ASSESSMENT REPORT

1 Burroway Road, Wentworth Point SSD 6387 MOD 4

Project Title
JEWEL RETAIL
1 BURROWAY RD, WENTWORTH POINT, THE WHARF SITE.
SYDNEY OLIMPIC PARK
Drawing Title
CAFE DESIGN

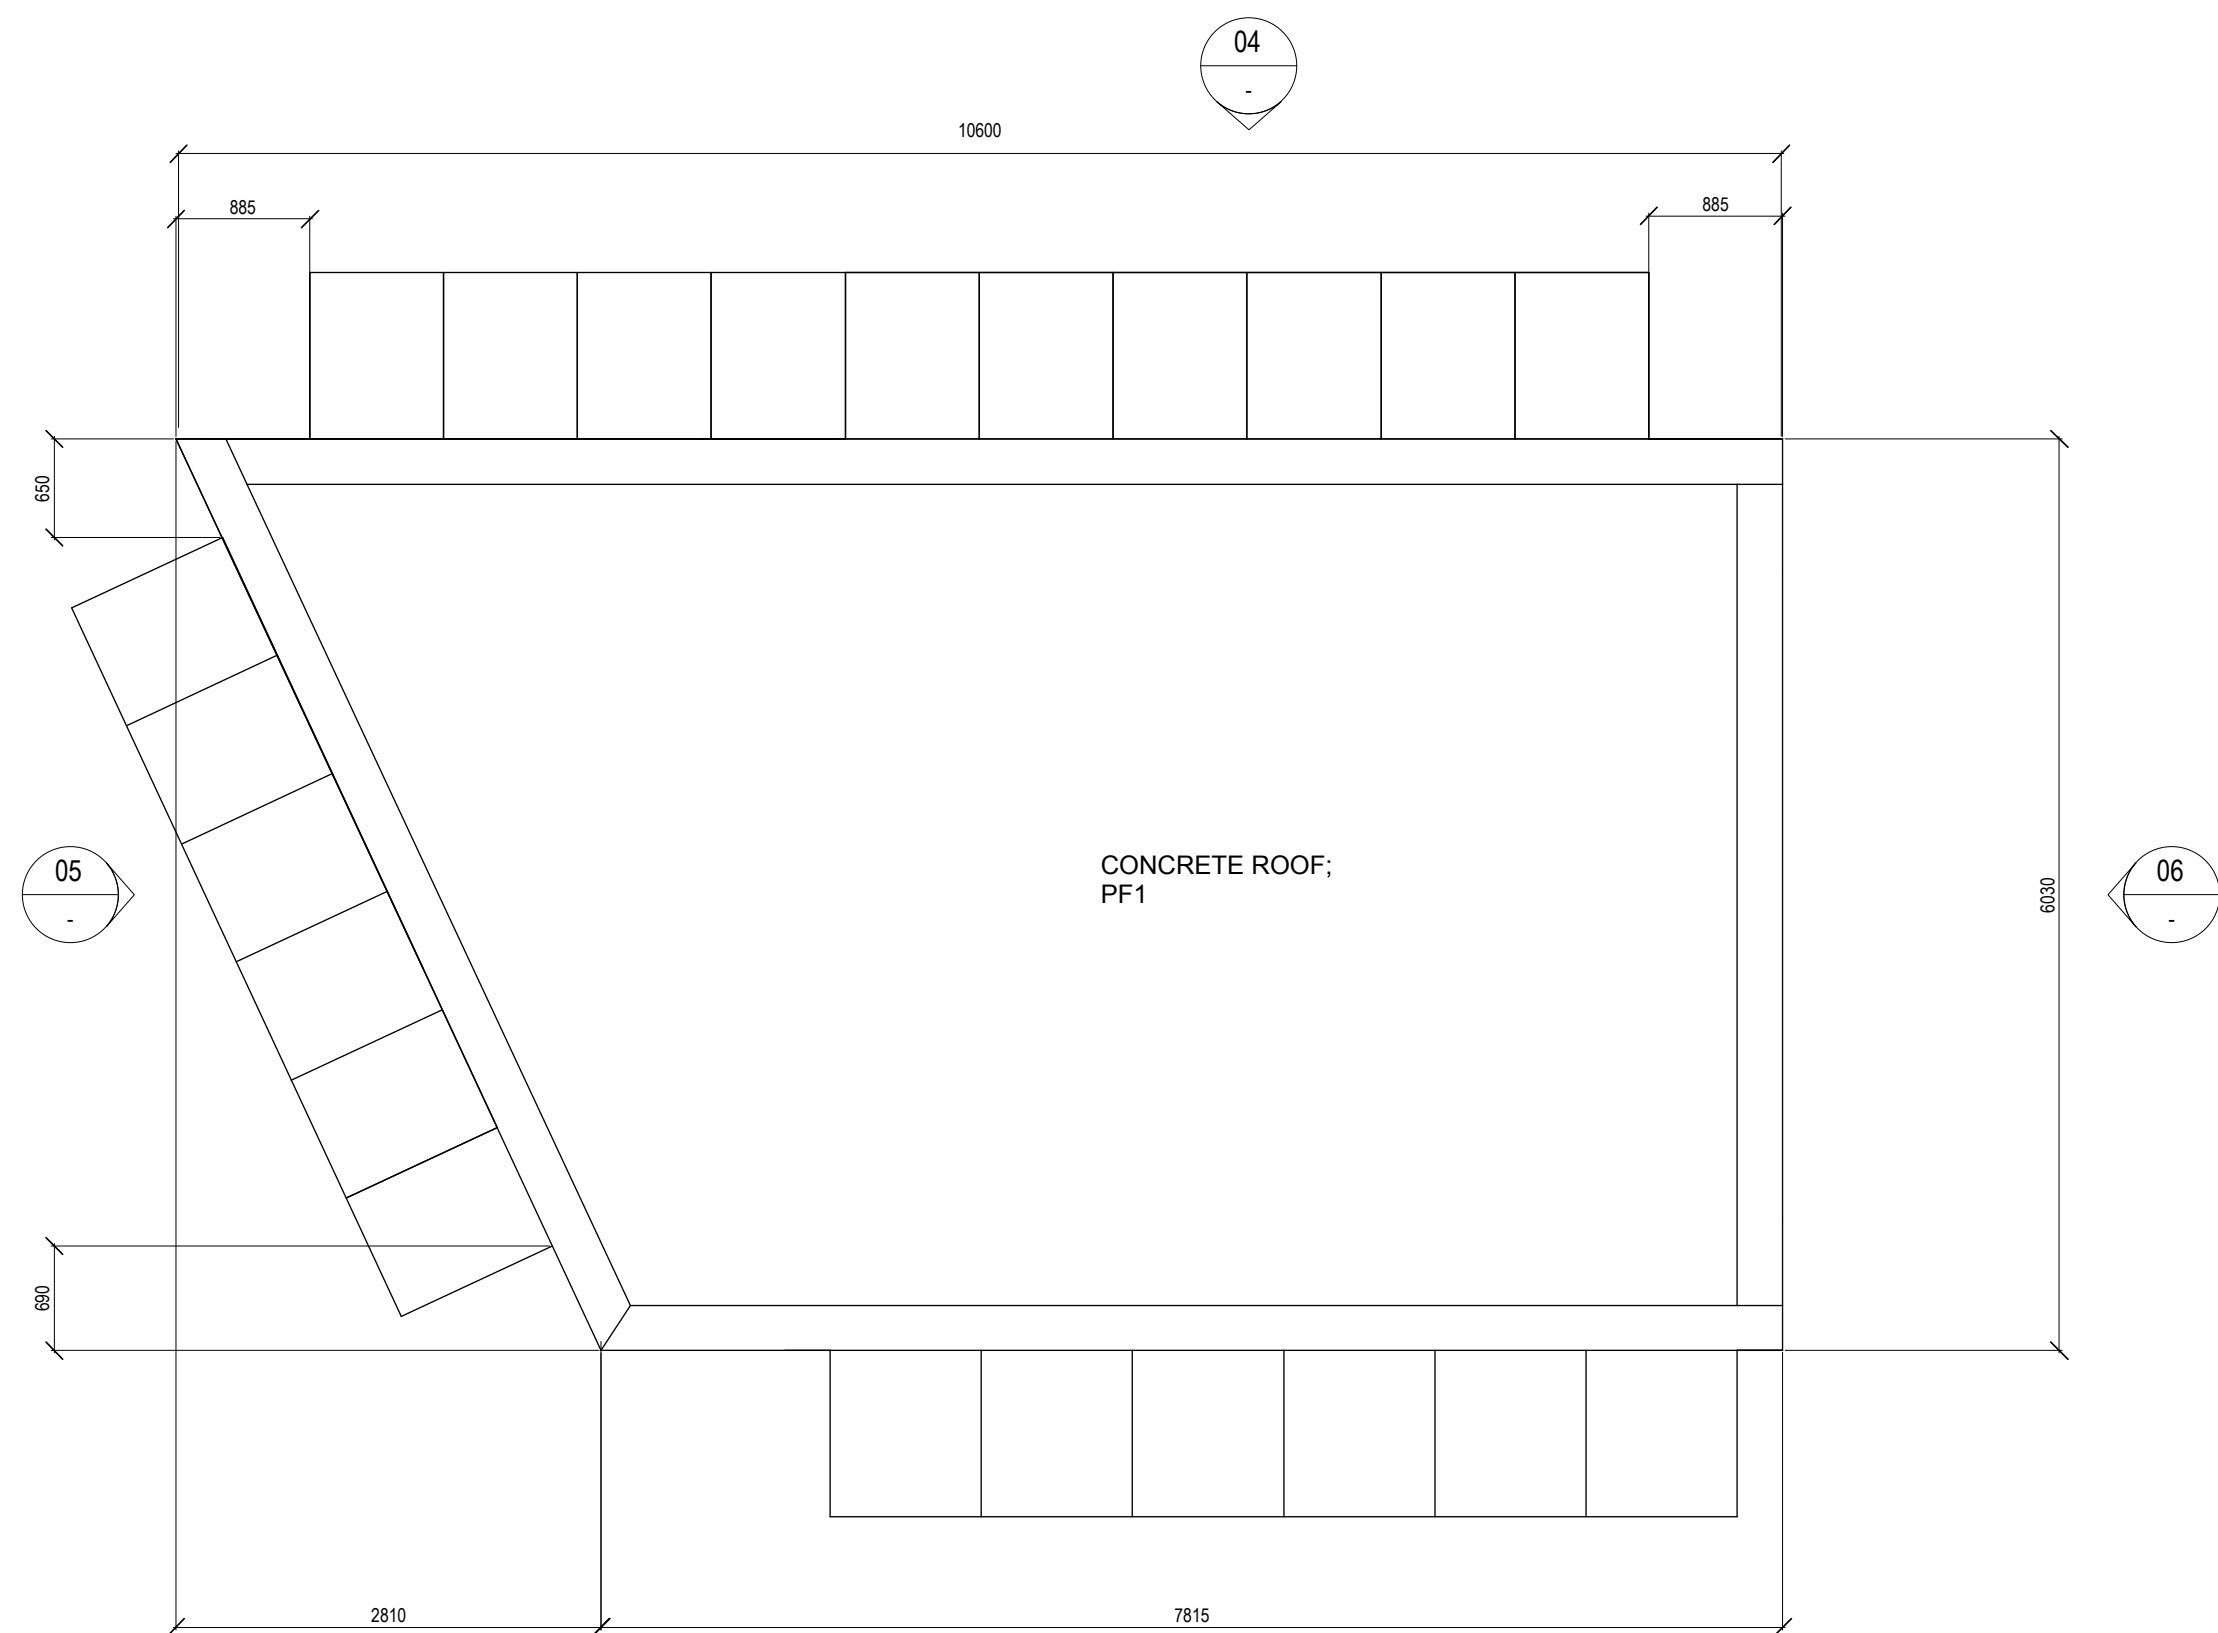
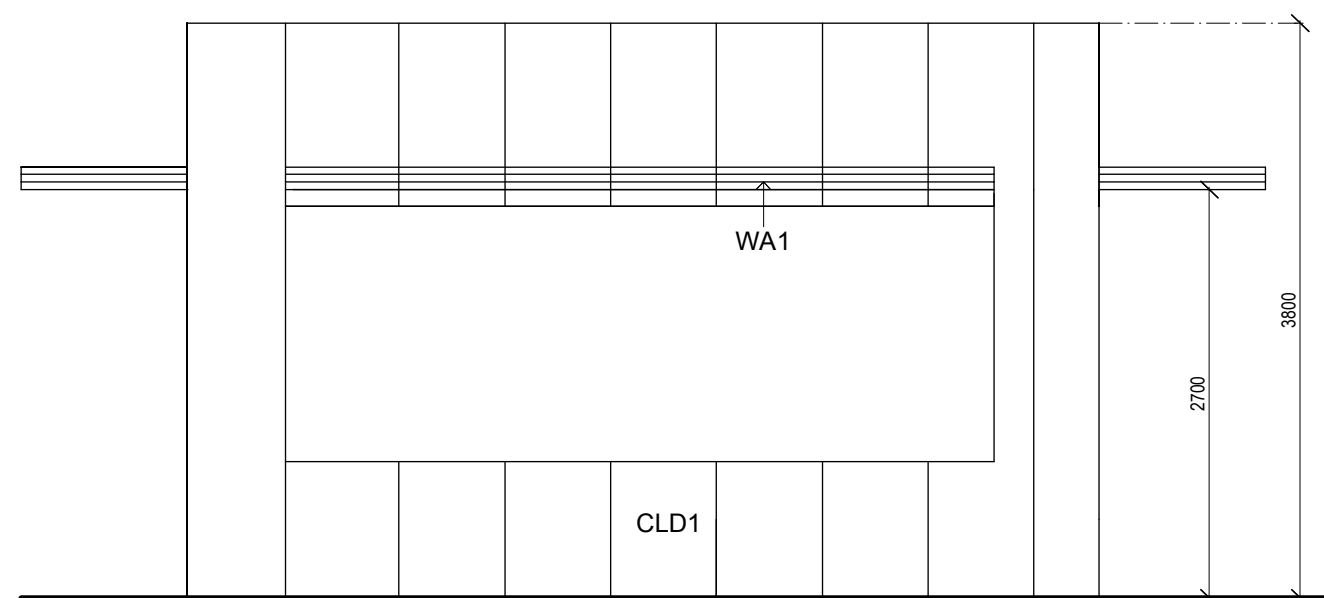
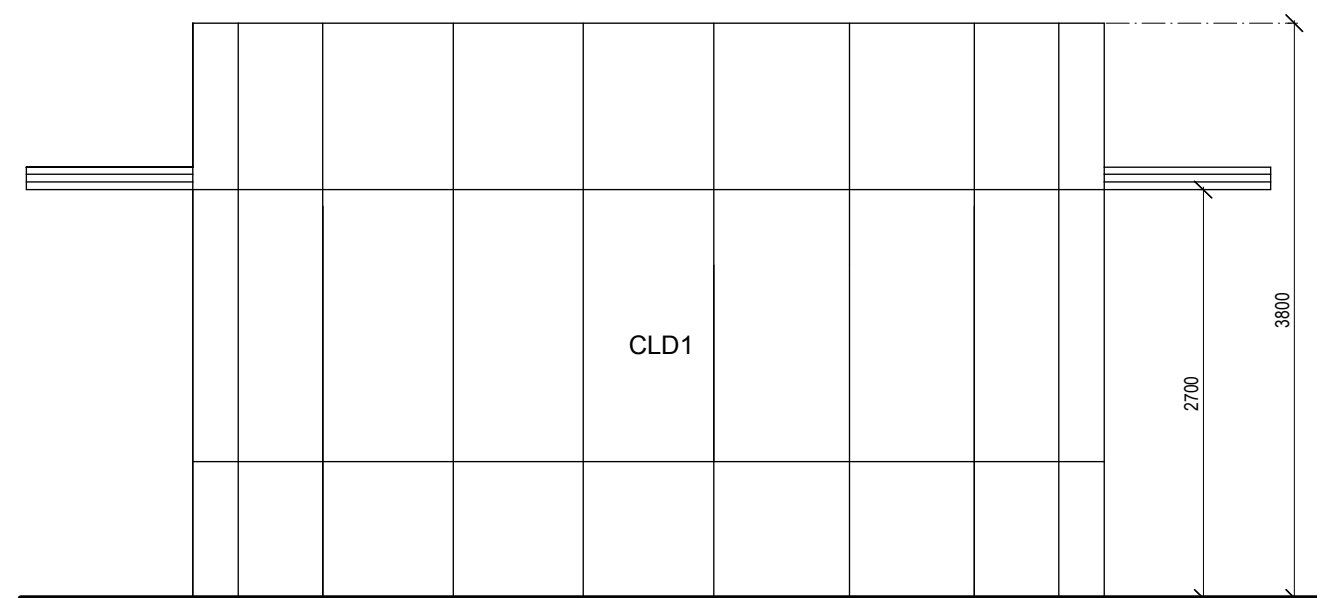
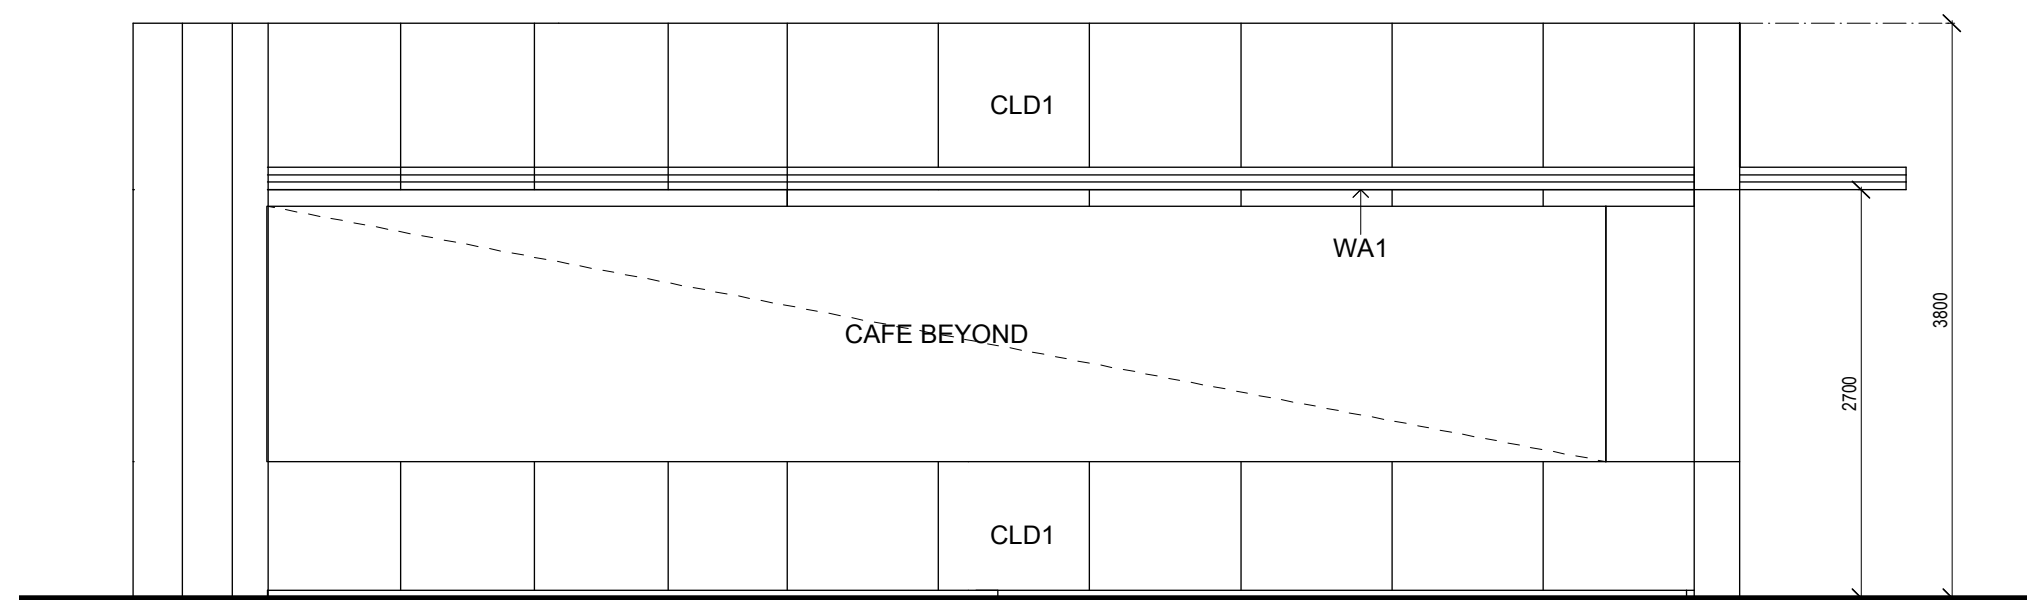
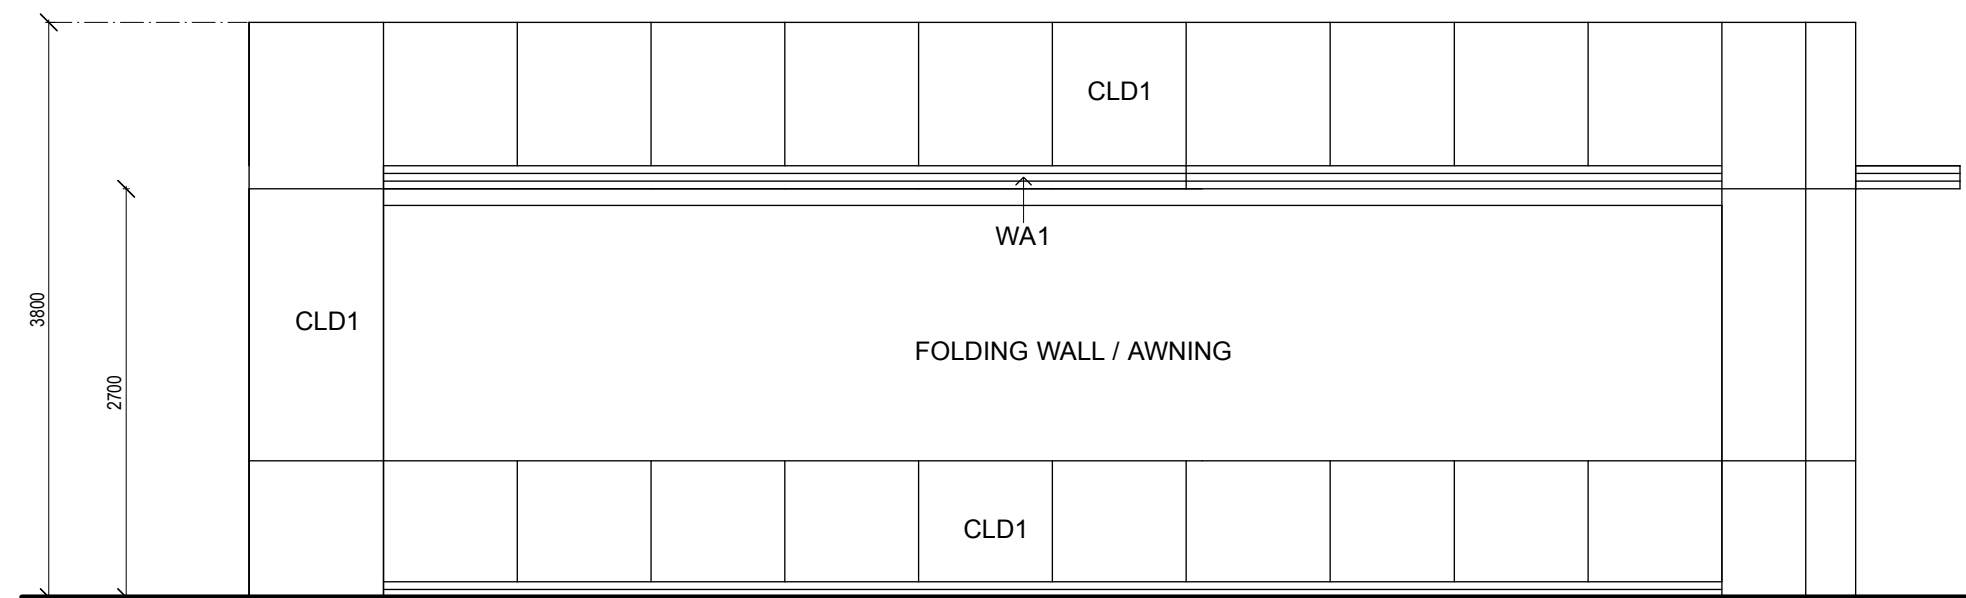
Council initially raised concern regarding the location of the café as it would impede the visual and pedestrian flows through the site. Following the amended scheme submitted with the RtS, Council raised no further objection to the location of the café, but recommended it be constructed of high quality materials. In relation to the canopy, Council recommended it be designed and constructed in accordance with the Building Code of Australia and designed to

SOPA raised no objection to the proposed canopy structure, but raised concern with the initial size and location of the cafe and the visual impact it would have on the through-site link. Following submission of the RtS, SOPA raised some issues relating to pedestrian movements within the area generally, and the need for a precinct wide pedestrian access strategy. The Department considers these issues are outside of the scope of the current modification request.

Issue	Consideration	Recommendation
<i>Public Domain Impacts (Cafe)</i>	<ul style="list-style-type: none"> • The proposal seeks approval for a new café at the entrance of an open air at-grade through-site link which provides public access between Burroway and Foreshore Roads to the ferry terminal. • SOPA and Council initially raised concern with the location and size of the cafe and the potential loss of visual connection to the foreshore and ferry terminal from Burroway Road. • In response, the applicant relocated the café to the west and reduced its size from 50 sqm to 30 sqm so a 10 metre wide through site link would be retained. • Council acknowledged the improvements of the revised proposal and considered it would minimise impacts on the public domain. • The Department considers the location and size of the proposed cafe (as amended) is appropriate given it would: <ul style="list-style-type: none"> – activate the entrance to the site on Burroway Road; and – maintain a 10 metre wide through-site link consistent with the requirements in <i>Wentworth Point Precinct Masterplan 2030</i>; – continue to allow direct pedestrian access to the ferry terminal and bus interchange; and – retain adequate visual permeability through the site. • The Department is also satisfied the café is appropriately designed to complement the architecture and design of the surrounding buildings and public domain. • The Department is therefore satisfied there would be no adverse impacts on the public domain. 	No additional conditions or amendments necessary.
